CITY OF PORTLAND

Job ID: 2011-06-1343-ALTR

has permission to Build a 12'x24 two story connector to a 24'x36' garage, 10'x23'3" sunroom, rebuild front porch & dormers provided that the person or persons, firm or corporation accepting this permit shall comply with all of the provisions of the Statues of Maine and of the Ordinances of the City of Portland regulating the construction, maintenance and use of the buildings and structures, and of the application on file in the department.

| ONE AND TWO FAMILY | PLAN REVIEW | CHECKLIST |

**PROPOSED FDN & SECTION PLANS  
HELLOU, ADDITION & REMODEL  
PORTLAND, ME**

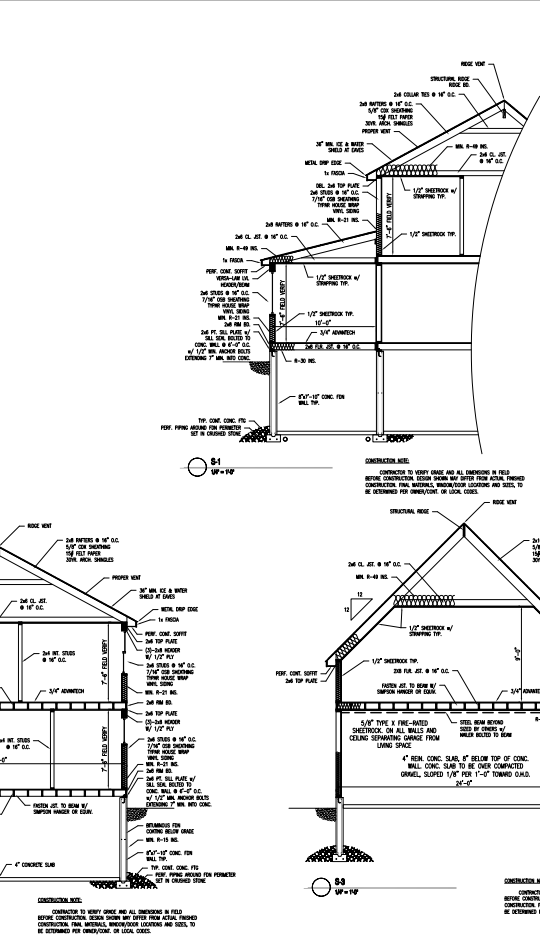
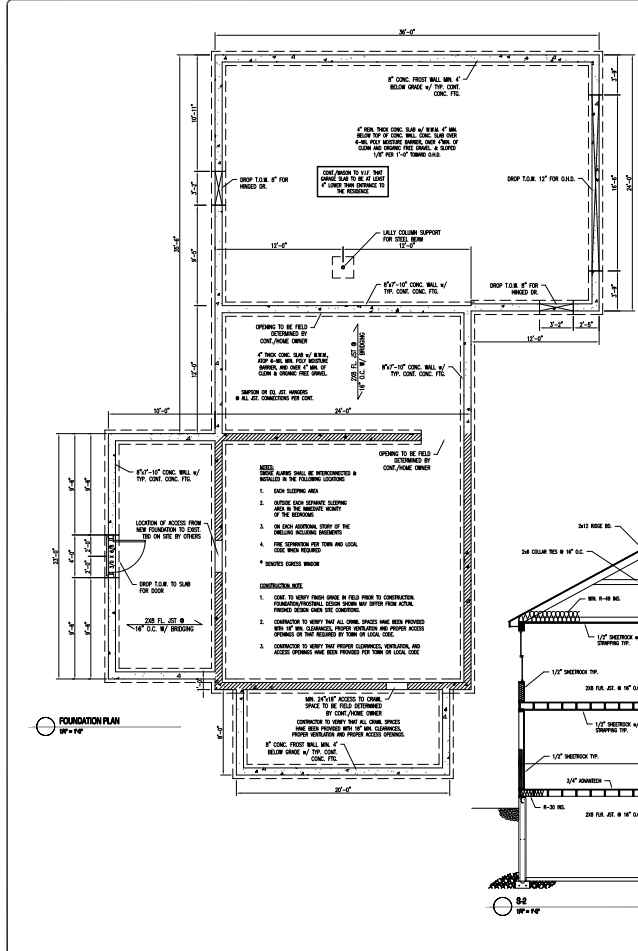
5. The structural details for the footings that support columns, and the OHD LVL spec for column support of the roof ridge beam shall be submitted prior to this work commencing.

| ONE AND TWO FAMILY | PLAN REVIEW | CHECKLIST |
|--|--|---|
| STRUCTURAL Footing Dimensions/Depth (Table R403.1 & R403.1(1), (Section R403.1 & R403.1.4.1) | 4" Thick slab w/ 6 mill 8" x 17'-10" Conc. Wall | ① Need Footings spec. OK 7/14 |
| Anchor Bolts/Straps, spacing (Section R403.1.6) | 6'-0" o.c 1/2" Anchor | ② Corner Bolts |
| Lally Column Type (Section R407) | | ③ Footing dimension |

Revisions:  
Date: 05/10/11  
Scale: 1/4"=1'-0"  
Drawn By: JTM  
Project: A0031111  
Sheet Number:  
6 of 6

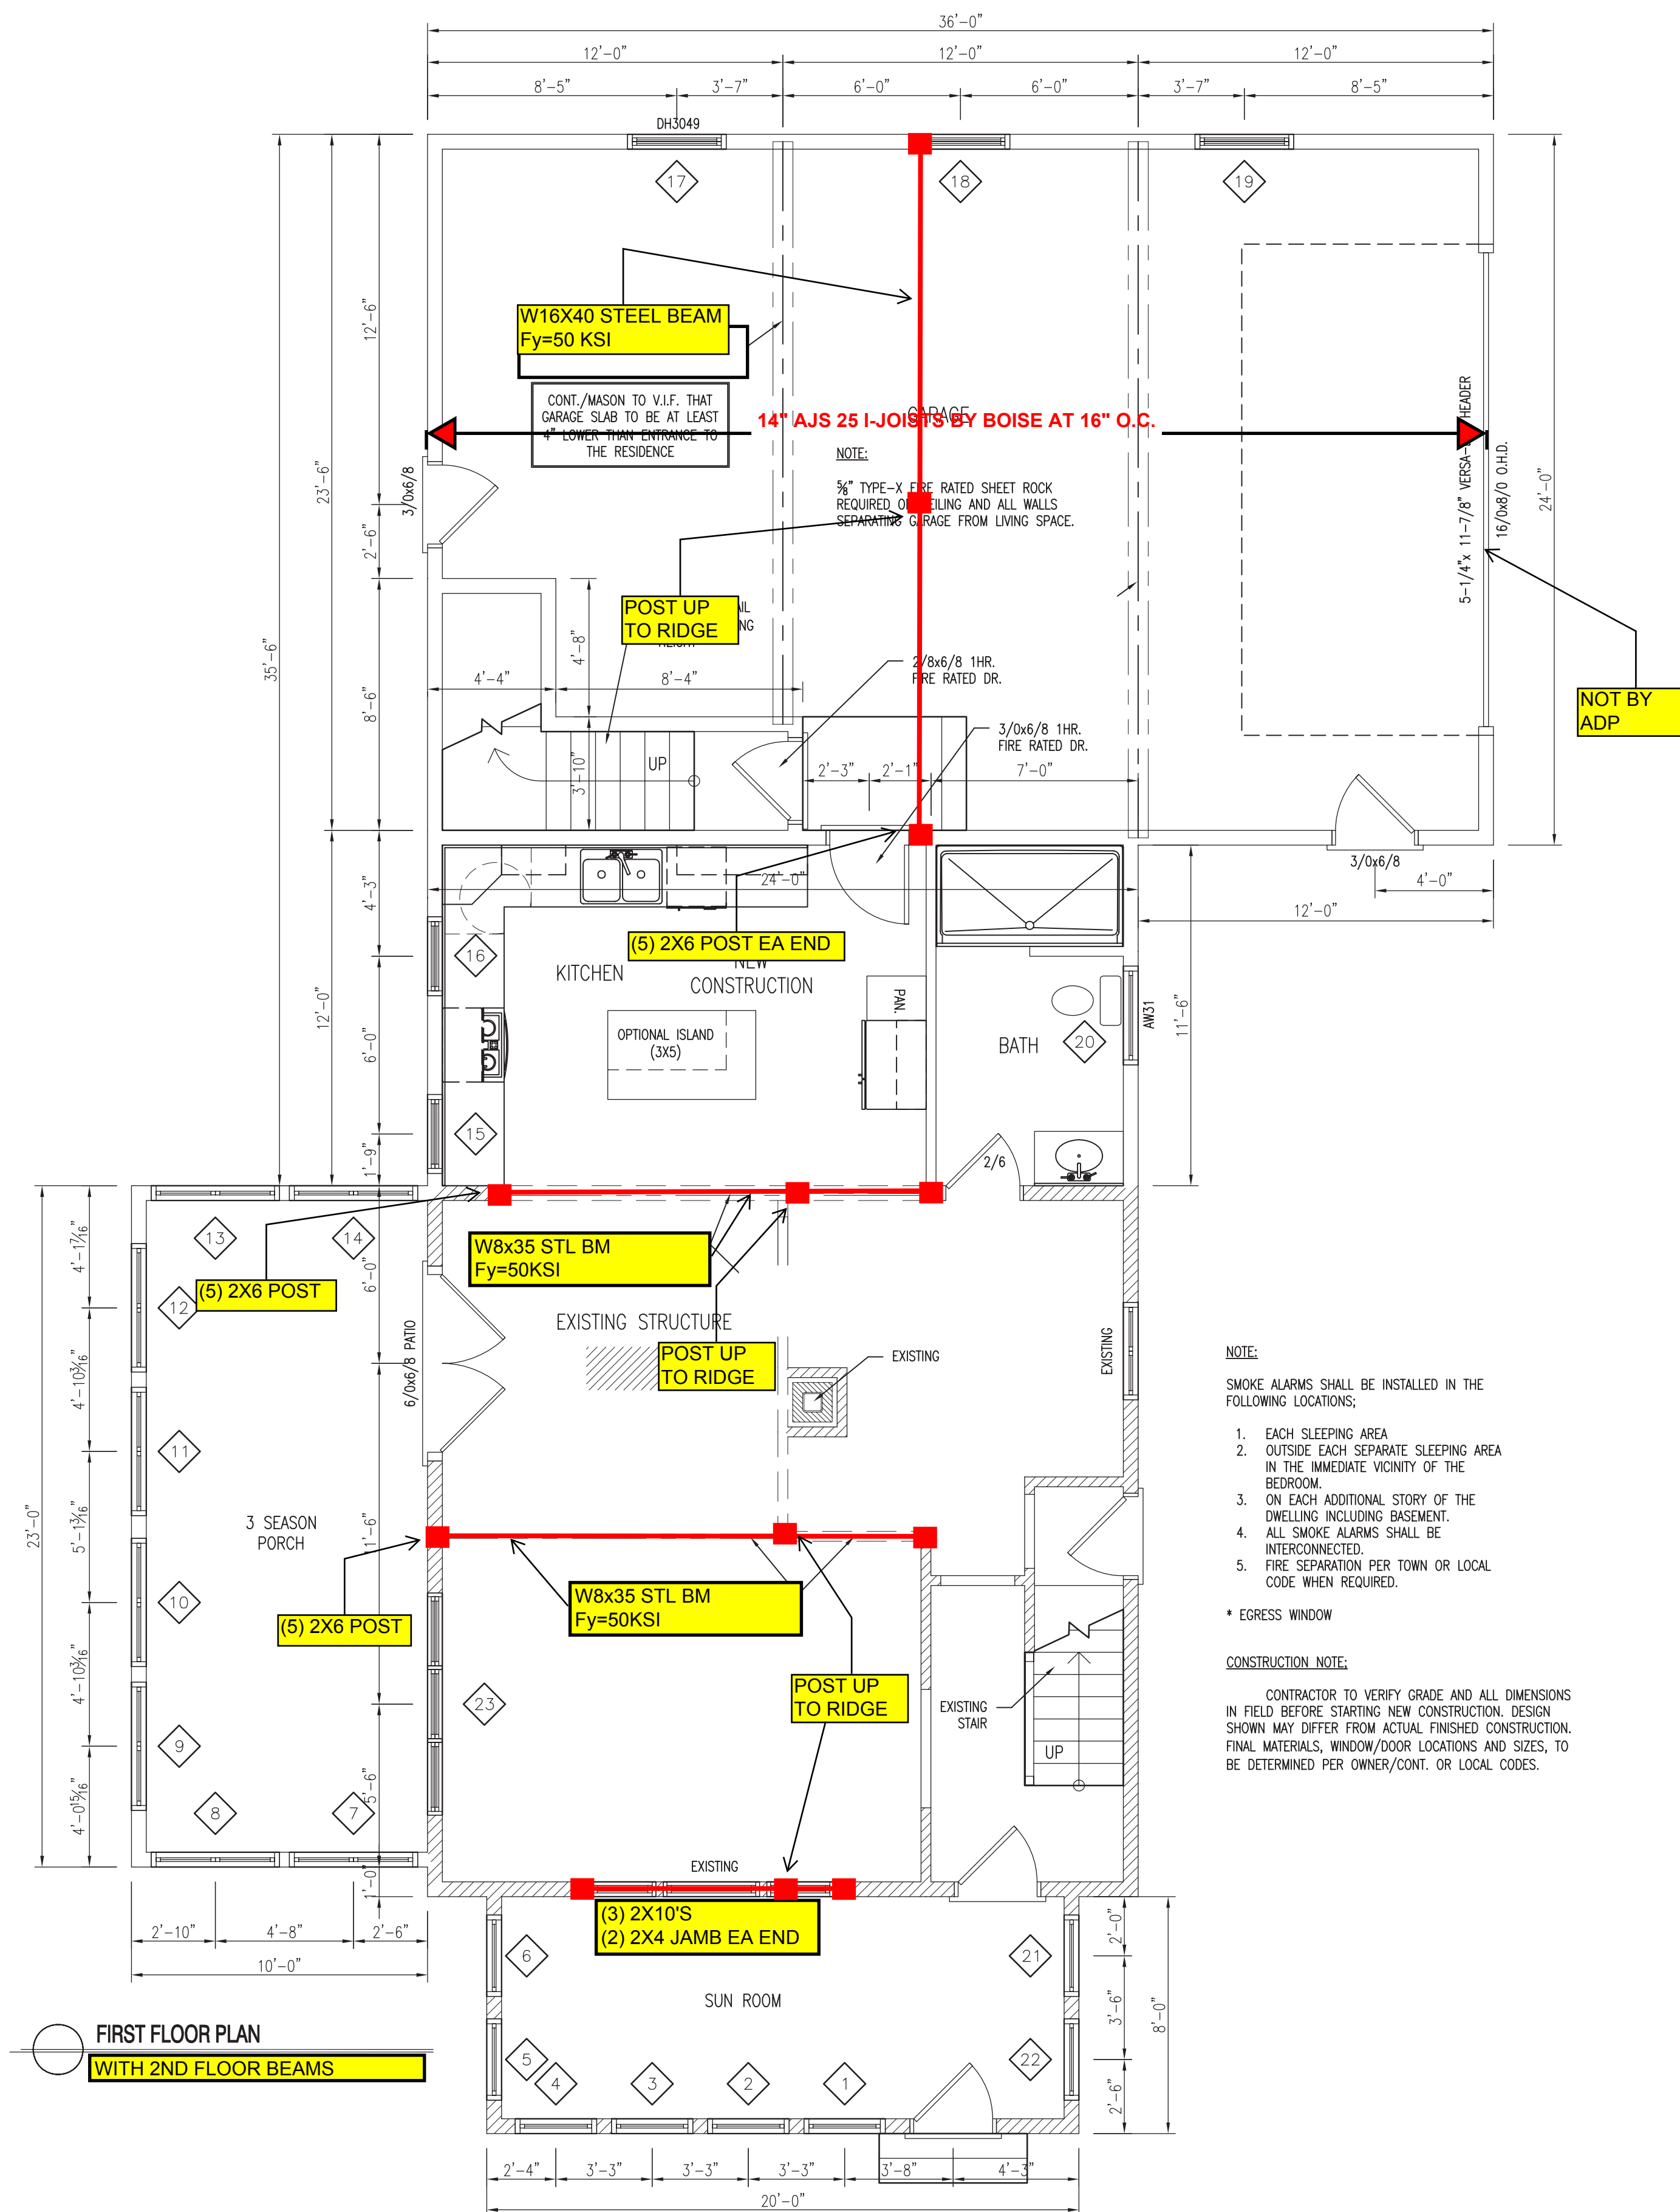
| ONE AND TWO FAMILY | PLAN REVIEW | CHECKLIST |
|--|--|---|
| Girder & Header Spans (Table R 502.5(2)) | see sheet 6 of 6 | |
| Built-Up Wood Center Girder Dimension/Type | | ④ Need specs (steel) in garage New beams existing house 7/14/11 OK |

Revisions:  
Date: 05/27/11  
Scale: 1/4"=1'-0"  
Drawn By: JTM  
Project: A8031111  
Sheet Number:  
5 of 6

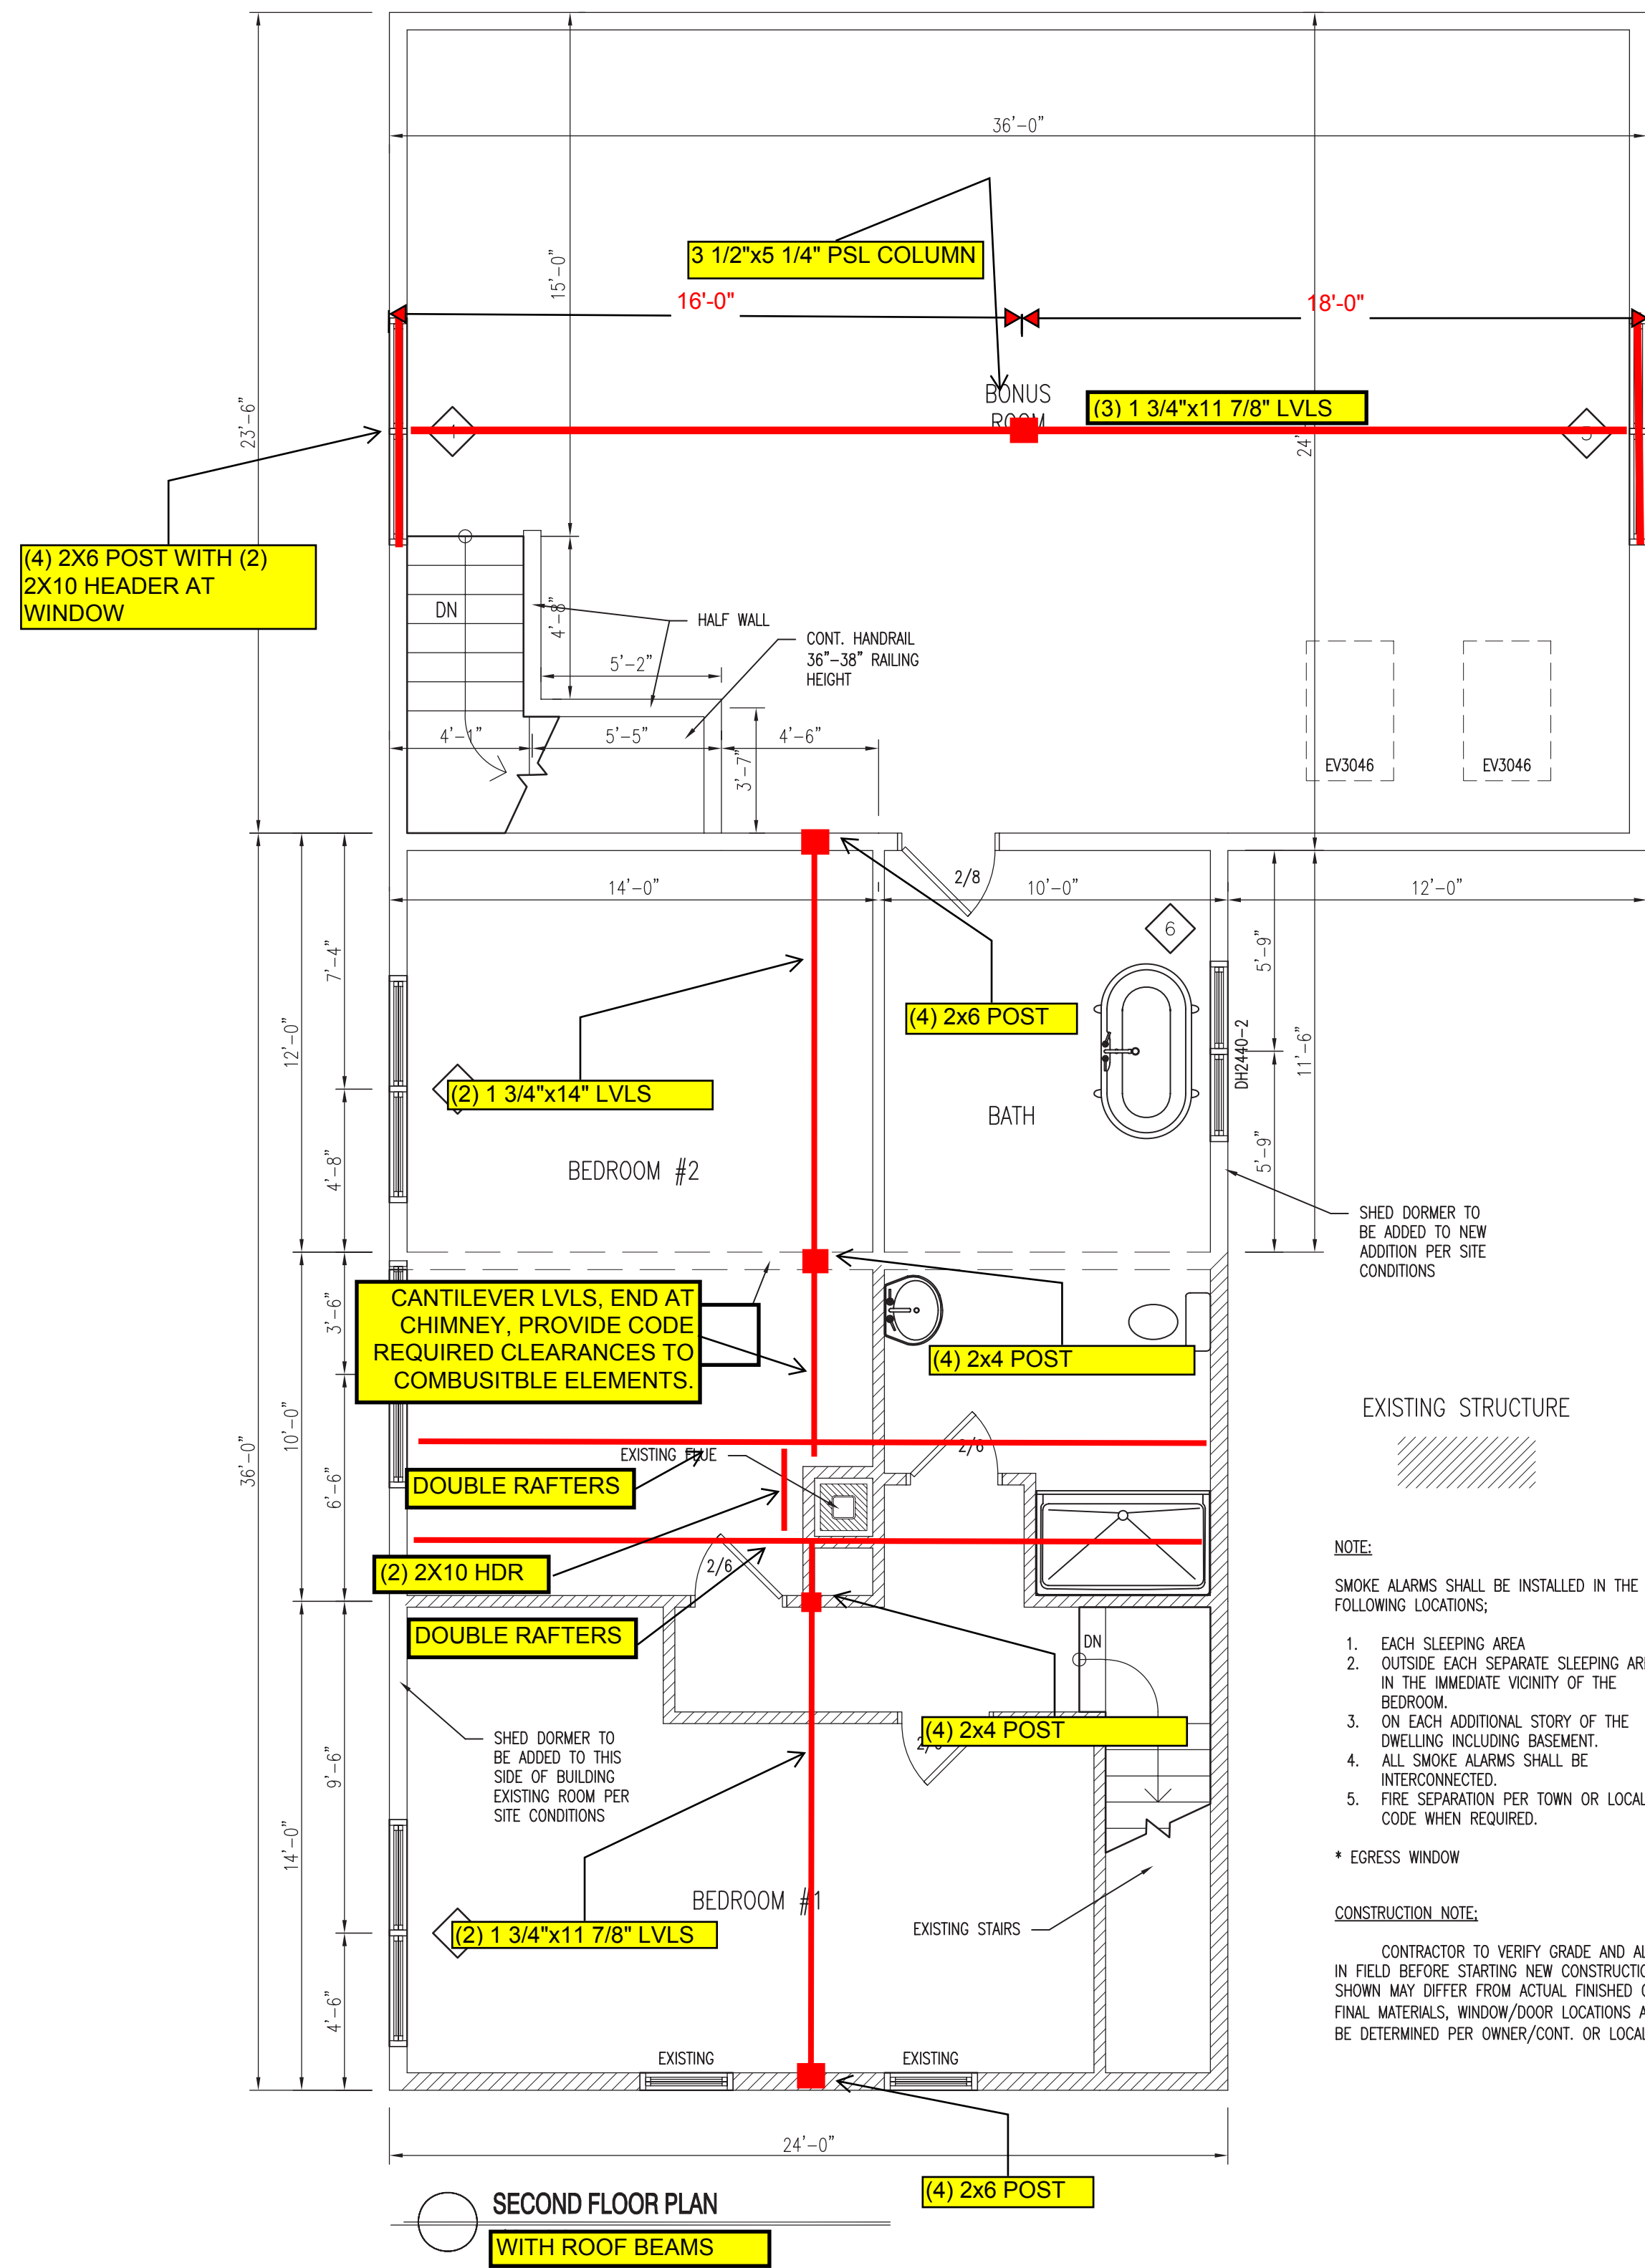
4. The floor above the garage is to be used for storage only, no habitable space due to the egress going through the garage. The only other access to the main house egress is through a bathroom, which is not allowed.

| Safety Glazing (Section R308) | Mark # 6 5 of 6 | ATTub condition ok 7/14/11 |

| Smoke Detectors (Section R313) Location and type/Interconnected | sheet 5 of 6 | cc Det. Req. |
